# CITY OF ALBUQUERQUE

October 6, 2016

**Re: North Towne Plaza Tract A-1  
5901 Wyoming  
Traffic Circulation Layout  
Engineer's Stamp 09-20-16 (E19-D033)**

**SITE PLAN FOR  
 BUILDING PERMIT**

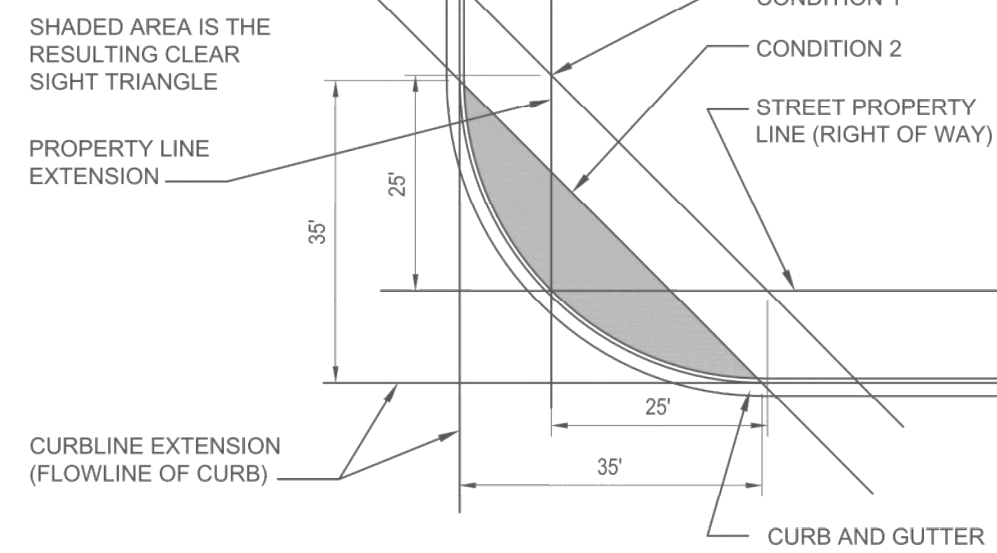
1. Please provide more detail for the ADA Curb Ramp located on the north corner, the grades, cross slopes and running slopes may be too large.
